**KIRKLEES METROPOLITAN COUNCIL
INVESTMENT & REGENERATION SERVICE**

Reference No: 2019/62/93705/E

Site Address: 14, Vernon Road, Heckmondwike, WF16 9LU

Description: Erection of single and two storey rear extension
(modified proposal)

SW ELEVATION AS PROPOSED - 1:100

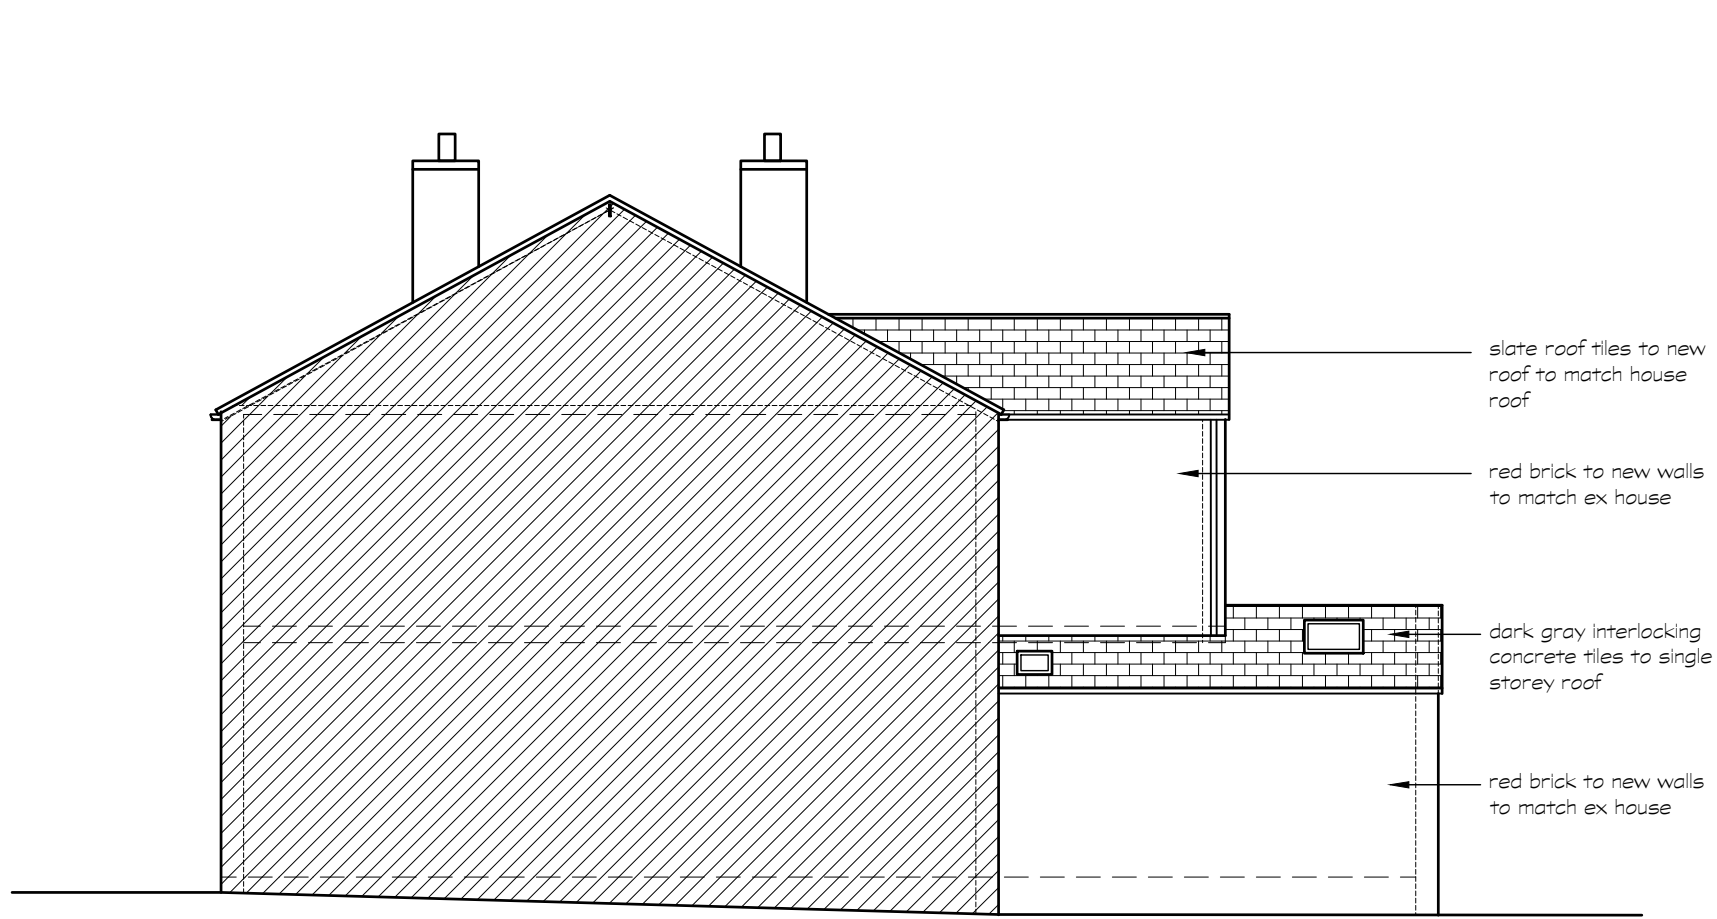
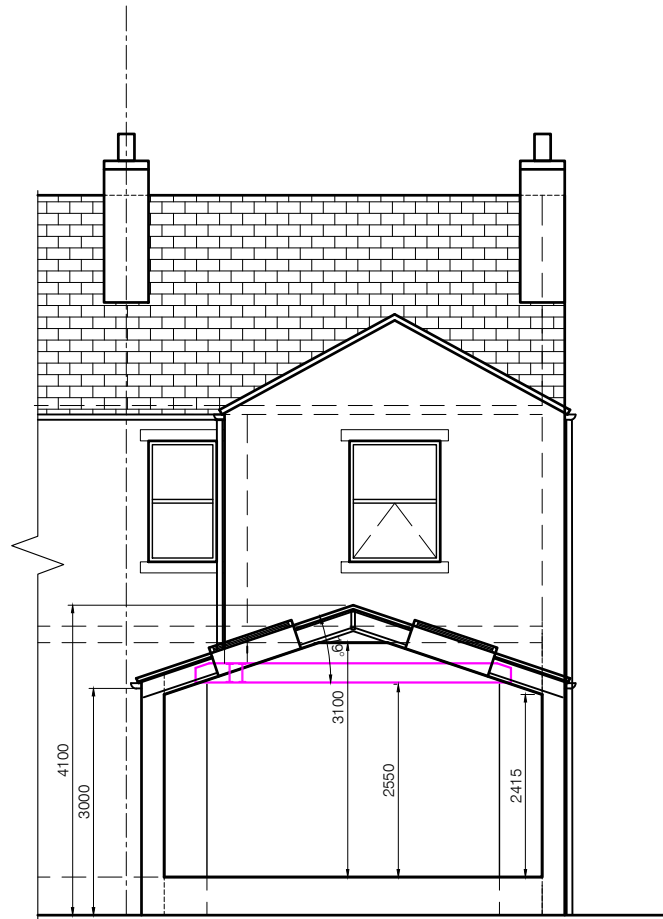
Amended plans were sought to reduce the overall height of the single storey rear extension. The agent provided amended plans introducing a gable roof form to reduce the height of the extension along the boundary shared with the adjoining property. The amended plans are considered, on balance, to address concerns regarding the impact on the residential amenity of the neighbouring property.

The single storey rear extension would be designed with a gable roof form which would be offset from the gable roof form at first floor level due to the differing width of the extensions. The gable roof form would also introduce additional bulk to the extension. Whilst the change in roof form would have some impact on the appearance of the rear elevation of the property, it is not considered, on balance, that it would be significantly harmful in terms of visual amenity. The extensions would not be visible from the street scene which would limit the impact that the development would have on the character of the surrounding area. The modified openings proposed for the rear and side elevations of the extensions are considered to be in keeping with the character and design of the existing property.

The ground floor element of the extension would be of an equal projection and a slightly reduced width to that approved under the previous application (2018/93968). The roof form would be altered to include a gable roof form

which would have an eaves height of 3.00 metres and a maximum height of 4.10 metres. Whilst the maximum height of the extension would be increased by 0.30 metres, it is noted that the gable roof form would move some of the bulk away from the boundary's shared with the neighbouring properties. As such, it is not considered that the potential overbearing or overshadowing impact would be significantly greater than previously approved. No openings are proposed for the side elevations of the extensions which would prevent overlooking. In line with the previous approval, it is considered acceptable to condition that no openings shall be erected in the south western side elevation of the single storey extension. It is considered that existing boundary treatment is sufficient should any new openings be erected to the north east. The restrictions of the General Permitted Development Order (GDPO) would prevent overlooking from any future openings which may be inserted at first floor level in the side elevations of the extension.
